ENG-SF22001-R1-FDR.pdf Markup Summary

CDurham (60)

## Pond C4 forebay overflow

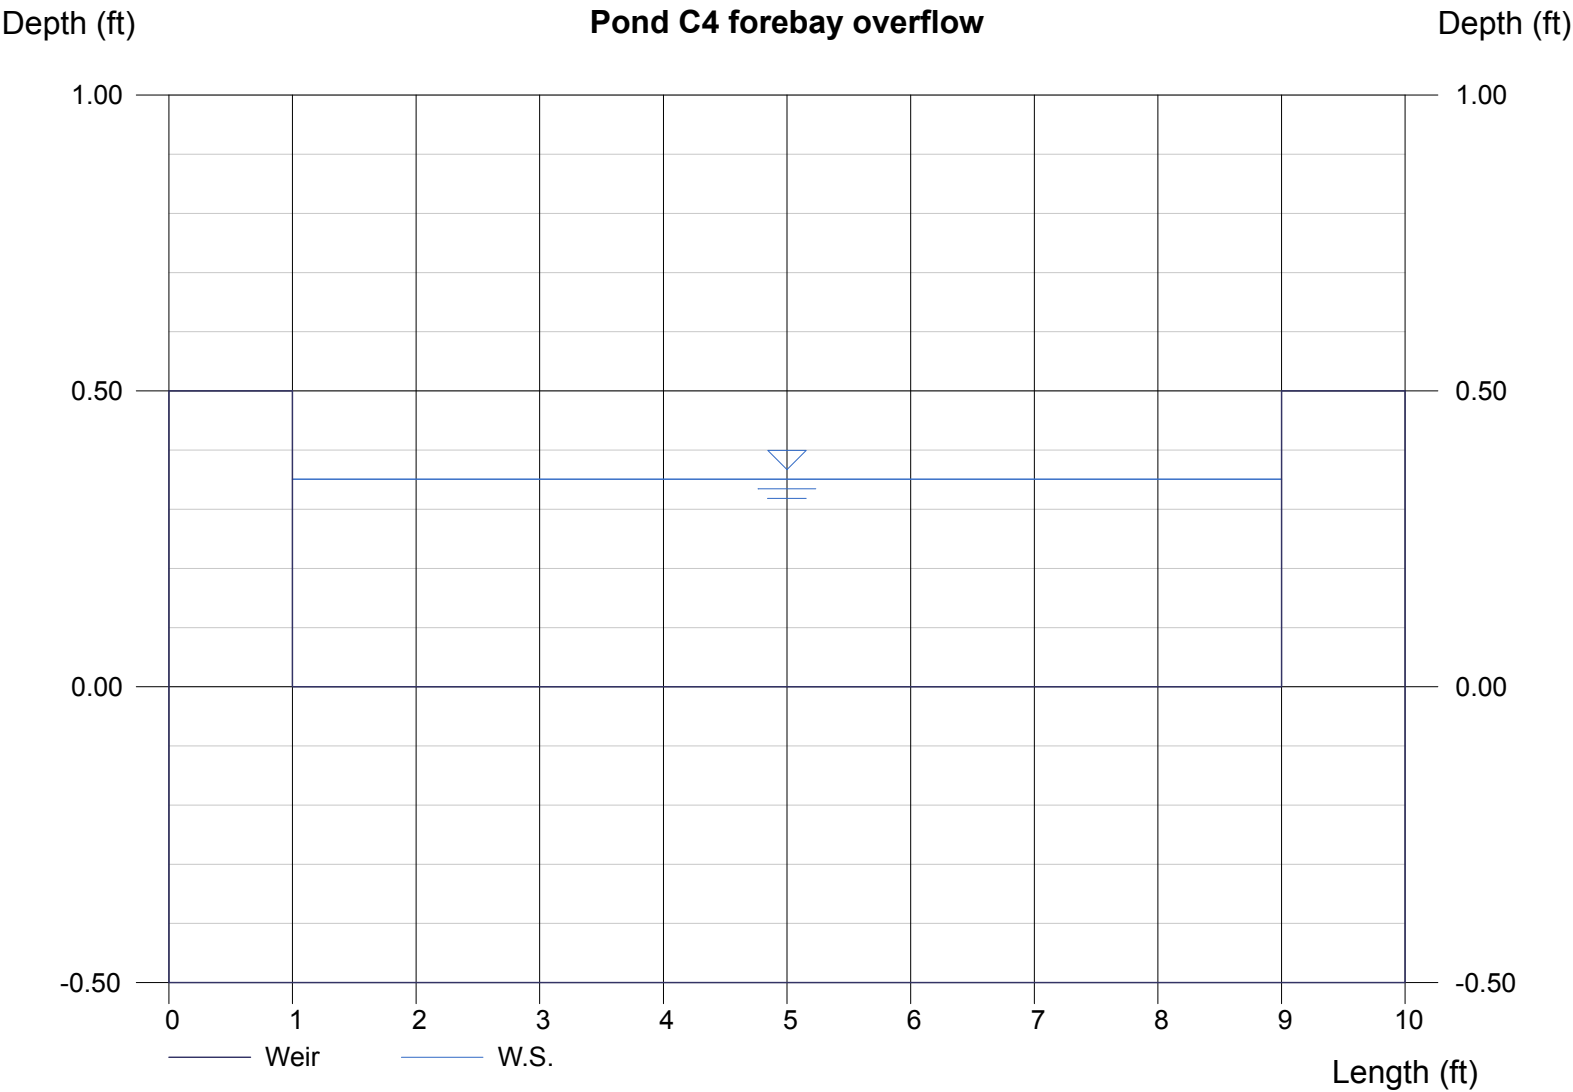
Include forebay notch sizing.

Include forebay sizing calcs.

DEVELOPED CONDITIONS
SKYLINE AT LORSON RANCH
C10 BASIN

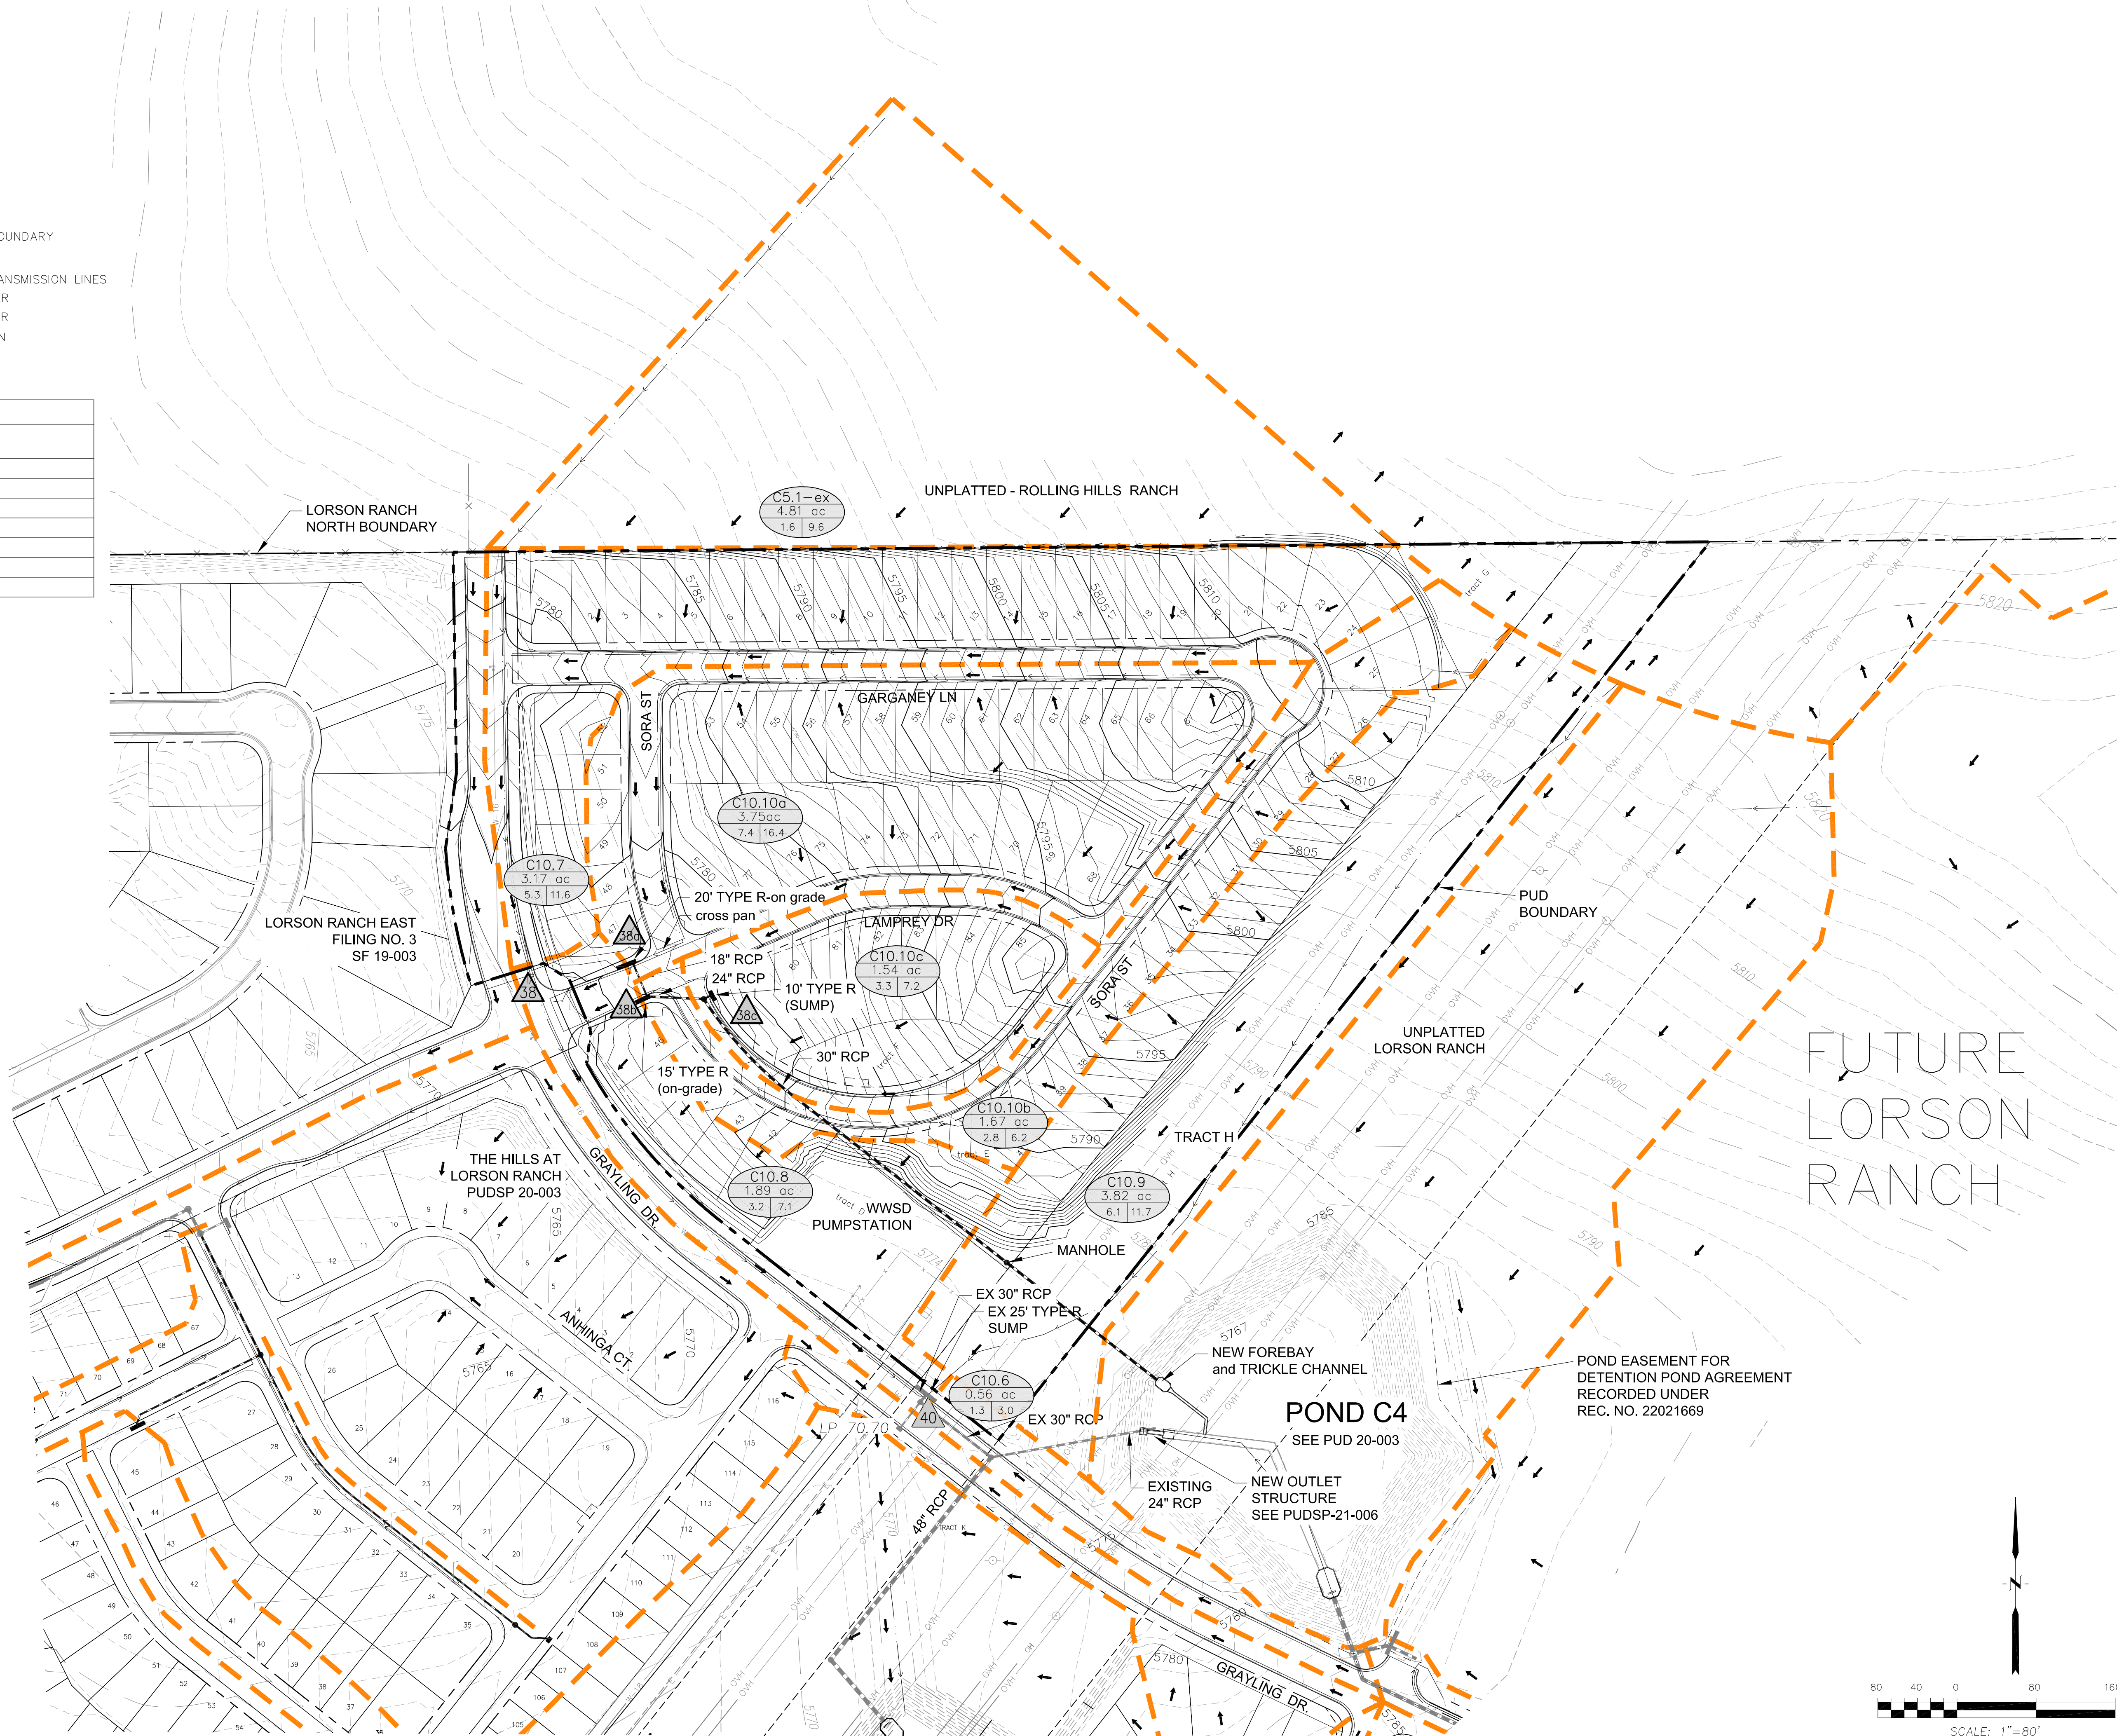
8.9 & 19.8 in spreadsheets

11.4 & 25.4 on spreadsheets

Label inlets as
sump or at-grade

Fix overlapping text

Turn on & label C&G

Label cross pan

Fix overlapping text

Label MH

show new trickle channel section too.
